UNLESS SUCH TIME AS THESE DRAWINGS ARE PREPARED, THEY ARE NOT TO BE USED FOR ANY PURPOSES WITHOUT THE WRITTEN AUTHORIZATION OF JACKSON DEARBORN PARTNERS.	
JACKSON DEARBORN PARTNERS 404 S. WELLS ST. SUITE 400 CHICAGO, ILL 60607 OFFICE PHONE (734) 216-2577	PREPARED FOR JACKSON DEARBORN PARTNERS 404 S. WELLS ST. SUITE 400 CHICAGO, ILL 60607 OFFICE PHONE (734) 216-2577
JR ENGINEERING A Weisman Company Corporate: 303-440-8888 • Colorado Springs: 719-592-2888 Fort Collins: 970-451-9888 • www.jrengineering.com	PREPARED BY: JRM DESIGNED BY: JRM DRAWN BY: JRM CHECKED BY:
SOLACE AT CIMARRON HILLS - FILING NO. 1 SITE AND OVERALL UTILITY PLAN	SHEET 4 OF 32 JOB NO. 25174.00

UNTIL SUCH TIME AS THESE DRAWINGS ARE CANCELLED BY THE ENGINEERING AGENCIES, JR ENGINEERING APPROVES THEIR USE ONLY FOR THE PURPOSES DESIGNATED BY WRITTEN AUTHORIZATION.	
PREPARED FOR JACKSON DEARBORN PARTNERS 404 S. WELLS ST. SUITE 400 CHICAGO, ILL 60607 OFFICE PHONE (734) 216-2577	PREPARED BY JR ENGINEERING A Weitzman Company 303-740-0888 • Colorado Springs 719-552-2883 Fort Collins 970-491-8888 • www.jrengineering.com
No. REVISION H-SCALE 1"=50' V-SCALE N/A DATE 03/12/21 DESIGNED BY JRM DRAWN BY JRM CHECKED BY	BY DATE No

SHEET 4 OF 32  
 JOB NO. 25174.00

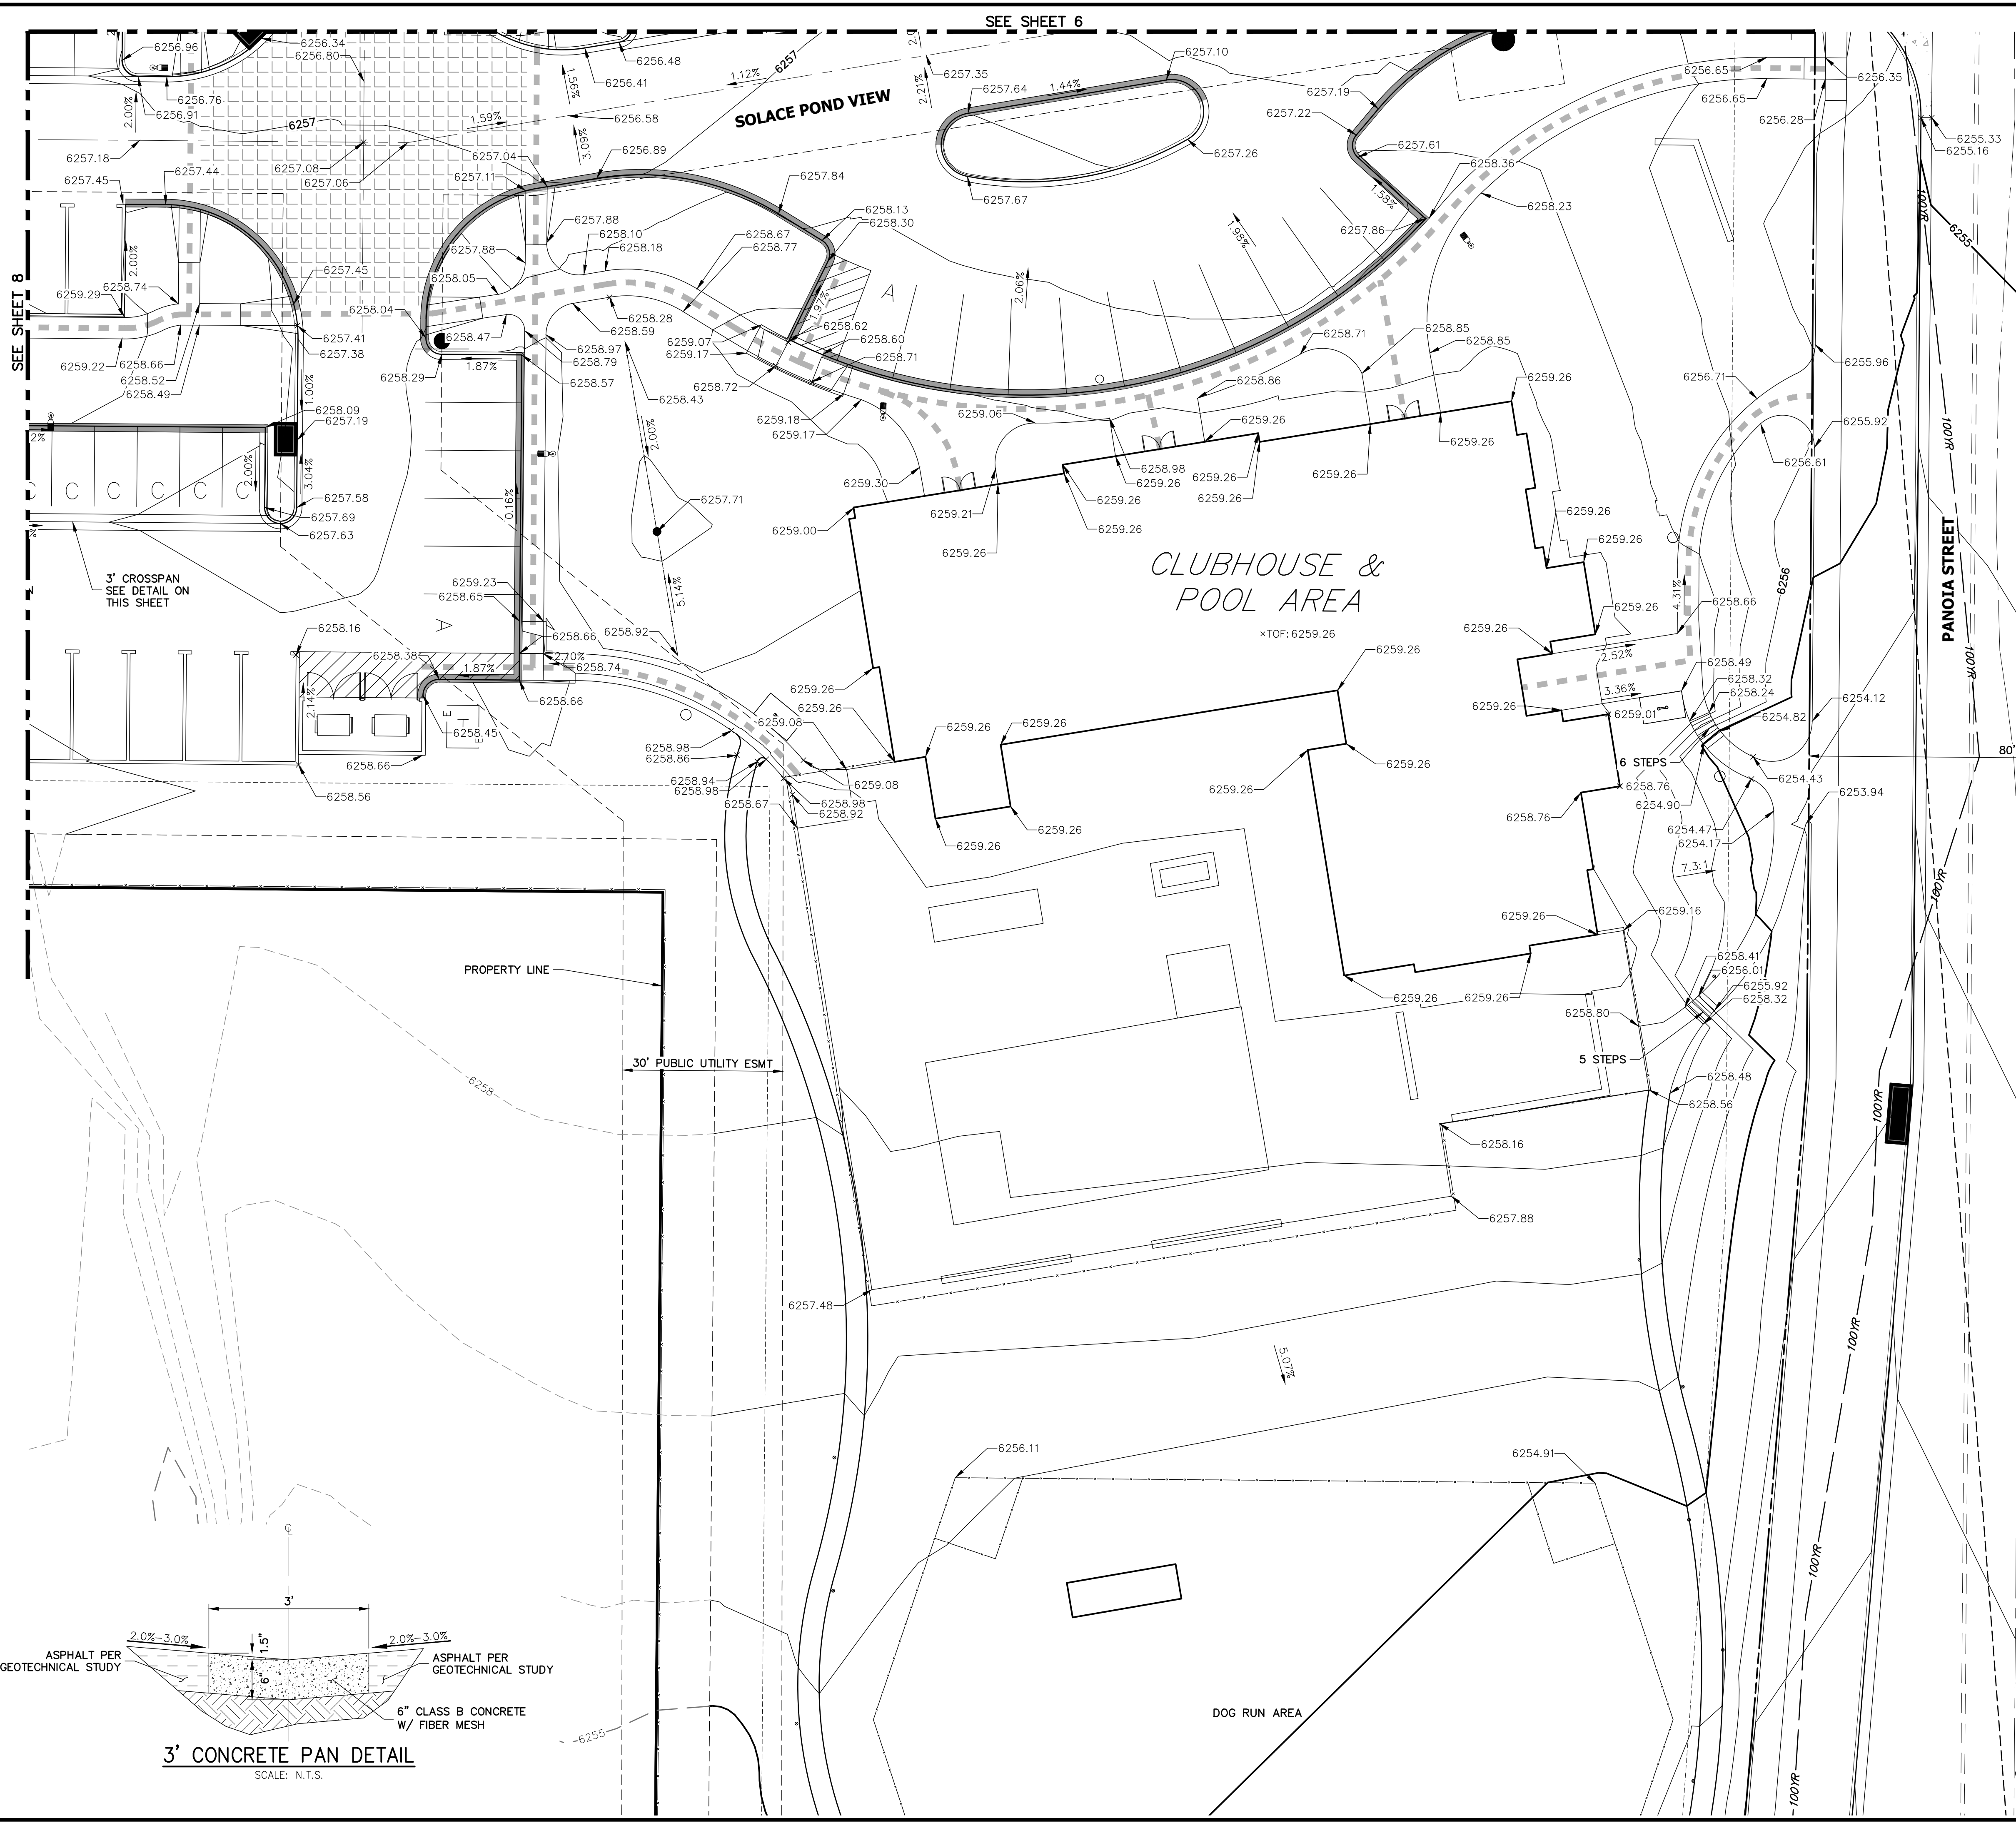
③ Label Service & FIRE LINES & PROVIDE PIPE SIZES & MATERIAL

- ① SHOW SANITARY SEWER CONNECTION TO BLDG.
- ② IF PUBLIC SANITARY WATER & SEWER SYSTEMS SUBMIT PIPE PROFILES W/ CROSSING DETAILS

④ IF PUBLIC WATER SYSTEM ADD NOTE THAT CHEROKEE RESPONSIBILITY ENDS AT MAIN TAP VALVE - SERVICE TO BLDG IS OWNER'S RESPONSIBILITY

⑤ ADD VALVES TO ISOLATE BUILDINGS

⑥ IF PUBLIC WATER & SANITARY SYSTEMS- ADD NOTE THAT OWNER RESPONSIBLE FOR PAVEMENT REPLACEMENT IF REPAIRS ARE NEEDED

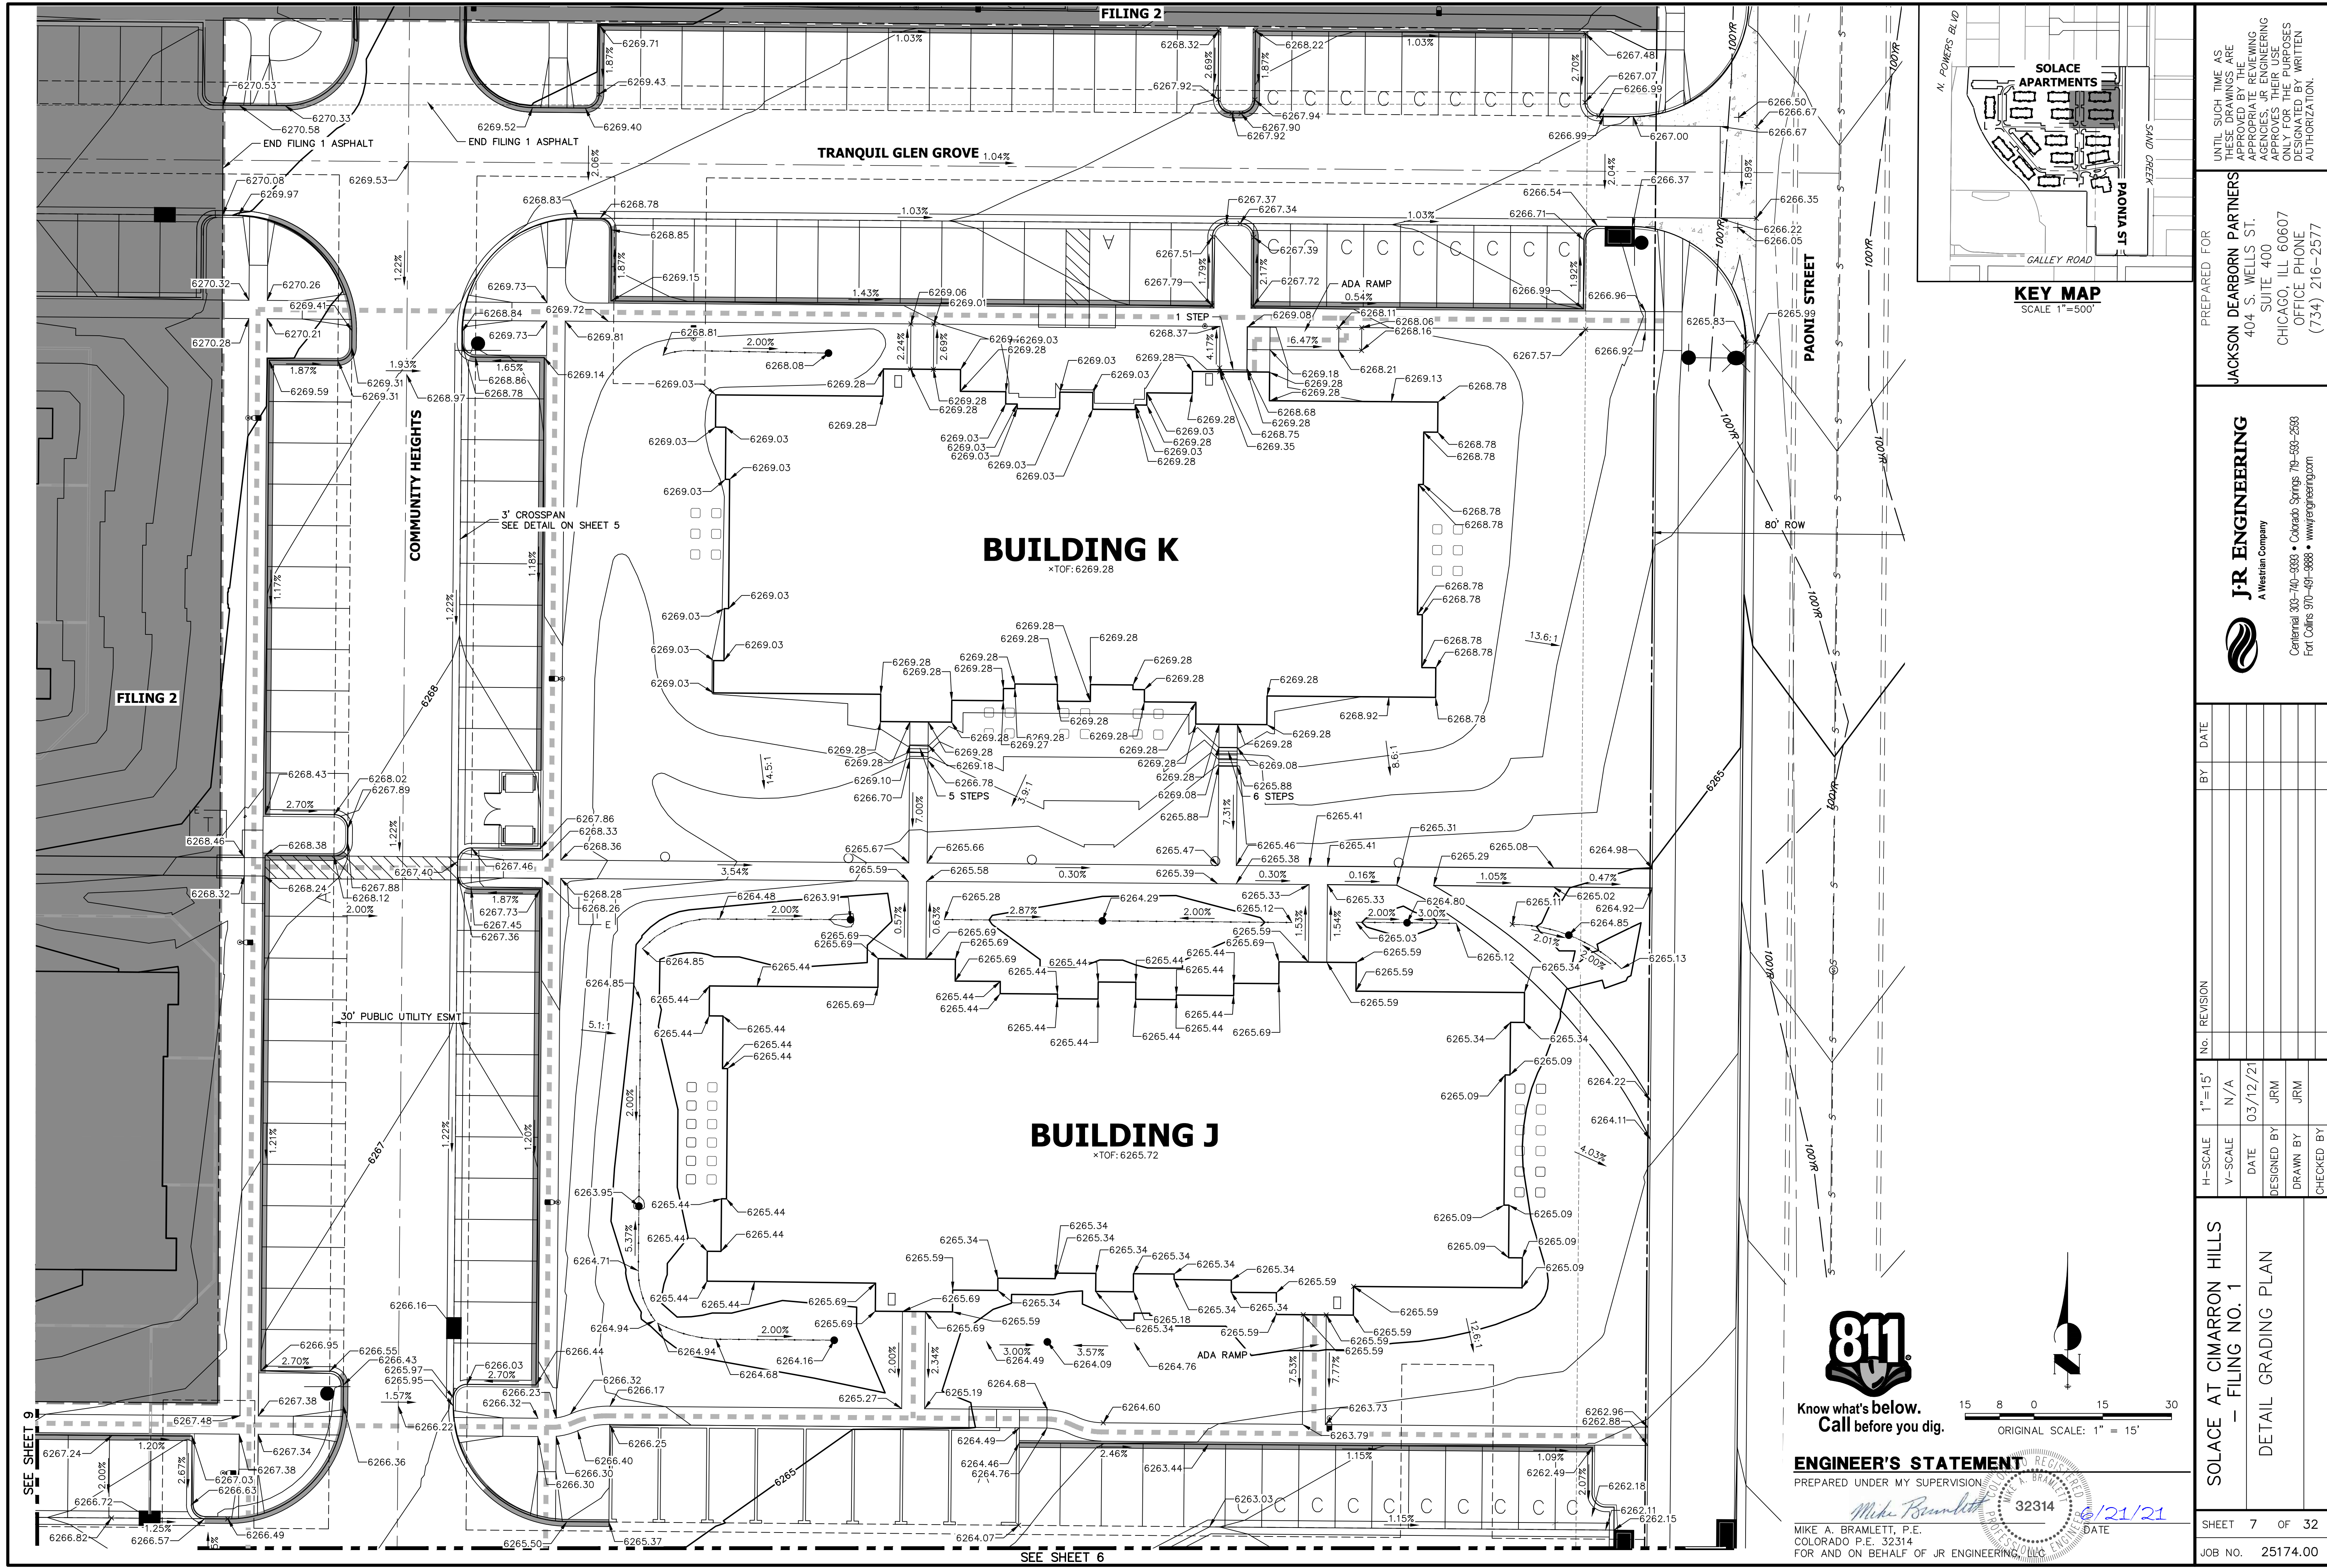
10' EASEMENT TOO NARROW
CONTINUE 30' EASEMENT
NO LANDSCAPING IN EASEMENT

3 - 8" VALVES
NO WATER LINE EXISTS
NORTH OF GALLEY. EXTENT
WATER LINE TO VALVE ON
SOUTH SIDE OF GALLEY

CONNECT
TO EXIST
VALVE
